HUNTER WATER CORPORATION
ABN 46 228 513 446
PO Box 5171
HRMC NSW 2310
36 Honeysuckle Drive
Newcastle NSW 2300

Our Ref: HW2015-1413/61

RE: CABBAGE TREE ROAD SAND QUARRY MODIFICATION 4 (SSD-6125-Mod-4)

From a review of the proposed Modification 4 report, the elements of the proposal that are of primary interest to Hunter Water include:

Figure 2A - Proposed Staging Plan Mod 4 Western Extension area

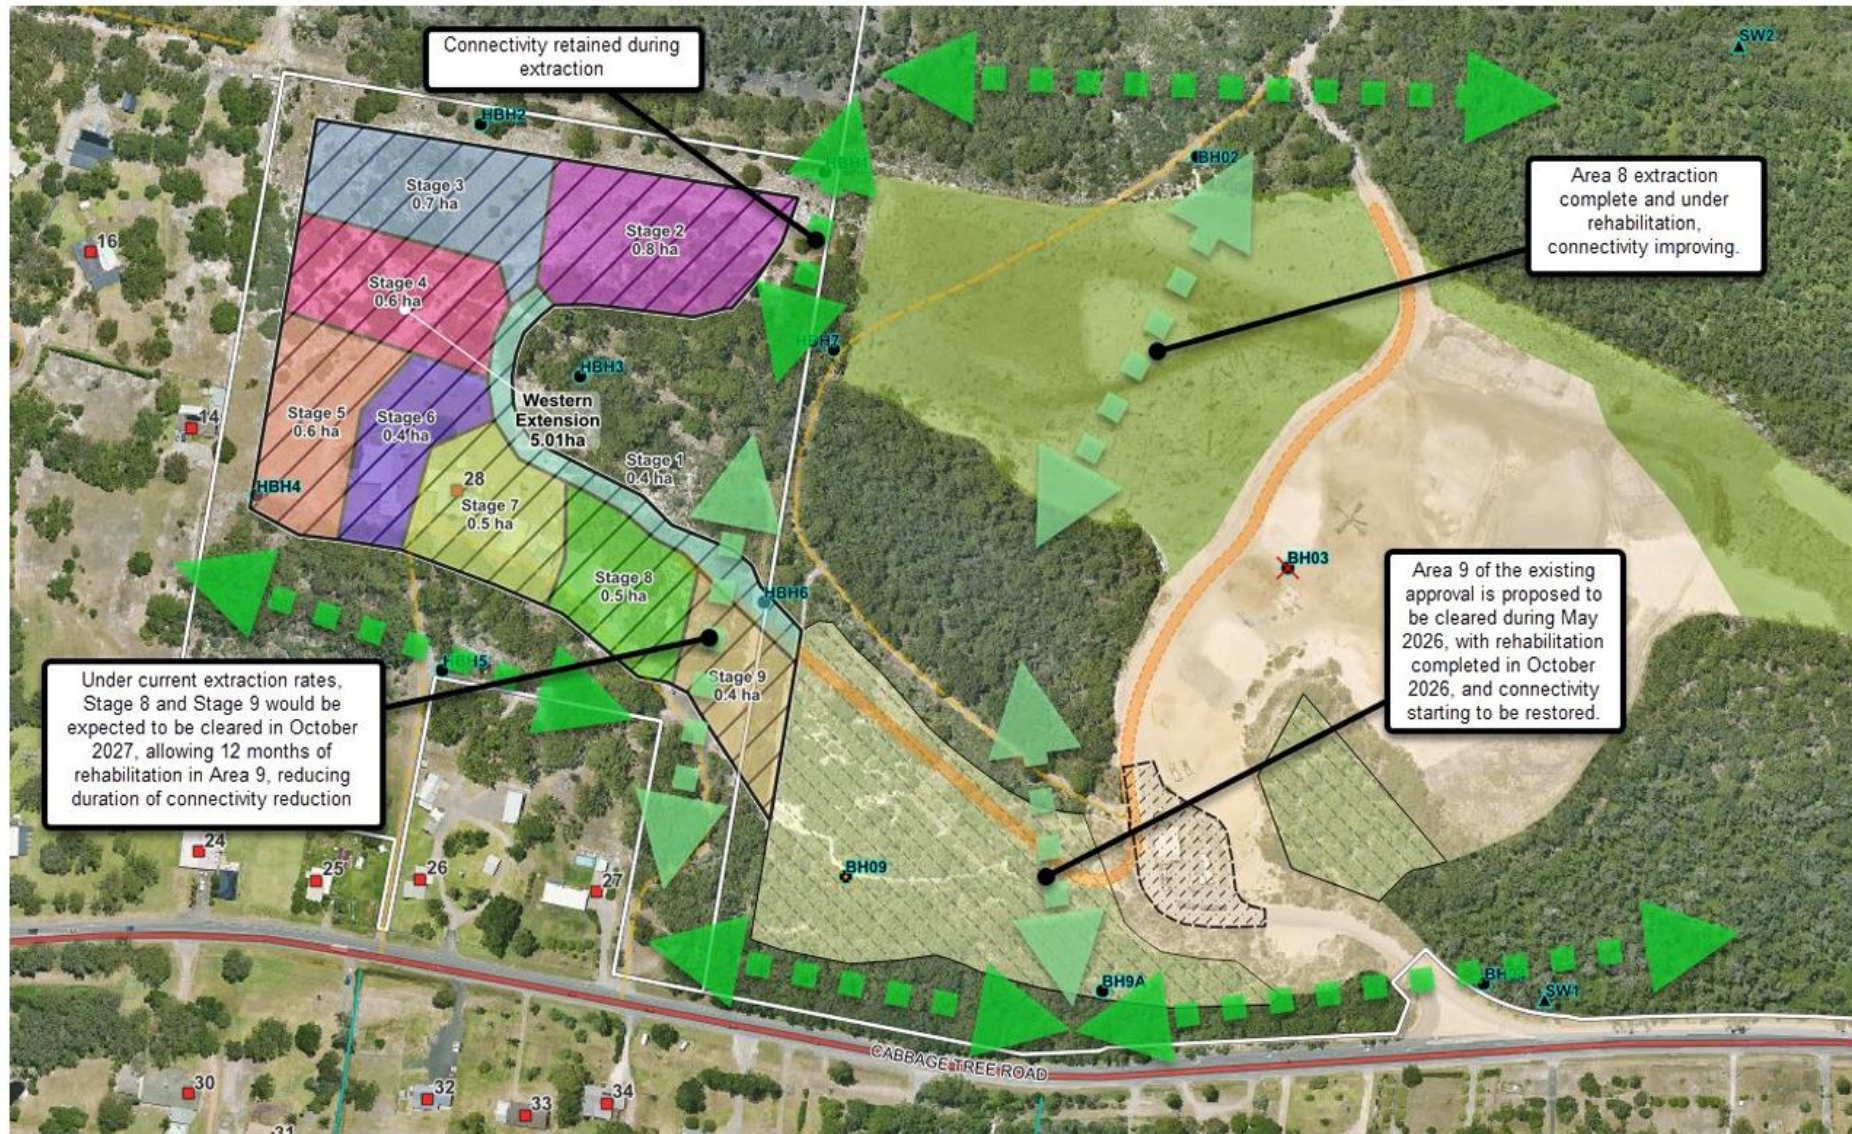
Western extension and resource boundary adjustments

The existing quarry operation has been designed to comply with the NorBE requirement, approval conditions have been imposed to ensure this occurs and these are supported by operating protocols and site management plans. Provided there are no proposed changes to operating methods that would impact on compliance with this requirement and the proposed additional management controls are implemented, Hunter Water has no objections to this aspect of the proposed modification.

Figure 3A: Conceptual rehabilitation plan for Western Extension area

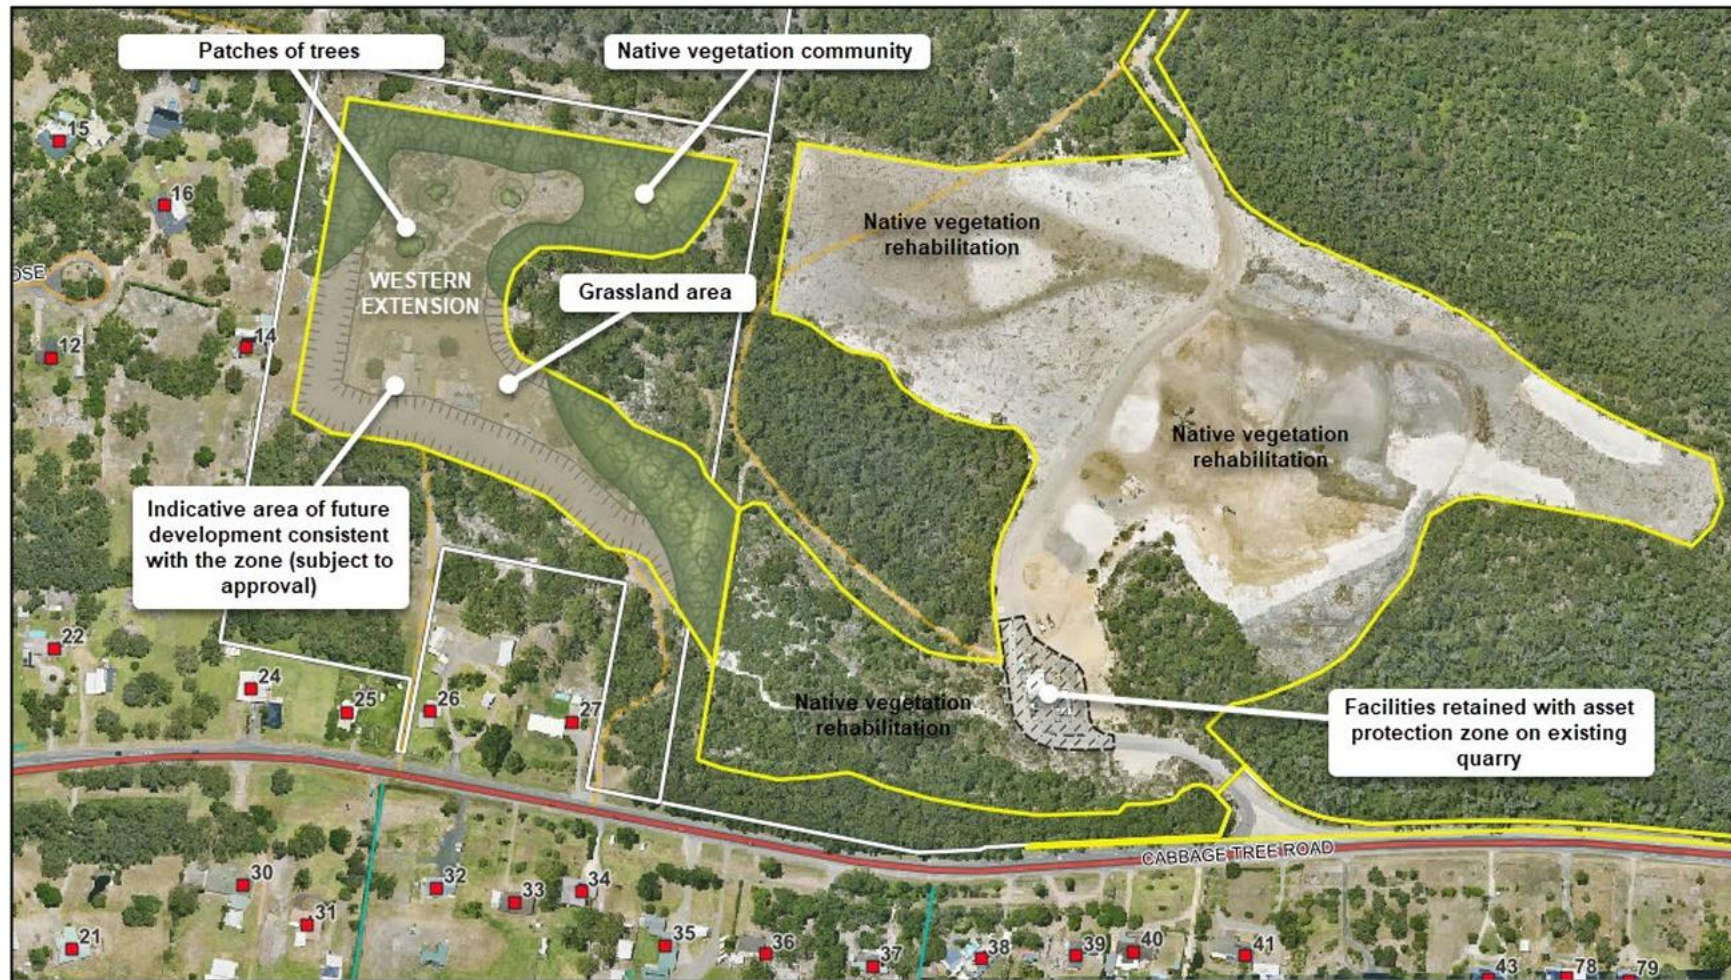
However, we note the higher level of disturbance in the proposed western extension area, the proposal to rehabilitate this area to grassland and the commensurate additional risks associated with achieving site rehabilitation objectives in other parts of the project area as a result of the disturbed land. This will require greater attention to detail and management of the site rehabilitation processes in parts of the site that are adjacent to the western extension area. Alternatively, rehabilitating the eastern part of the proposed western extension area with a native vegetation buffer (in the order of at least 30 metres) should assist greatly in achieving the rehabilitation objectives in other parts of the project area. In reality, the ongoing occupation and management of the western extension area after the completion of quarrying operations is considered to present a greater risk to the aquifer and surrounding residents than the quarry operations.
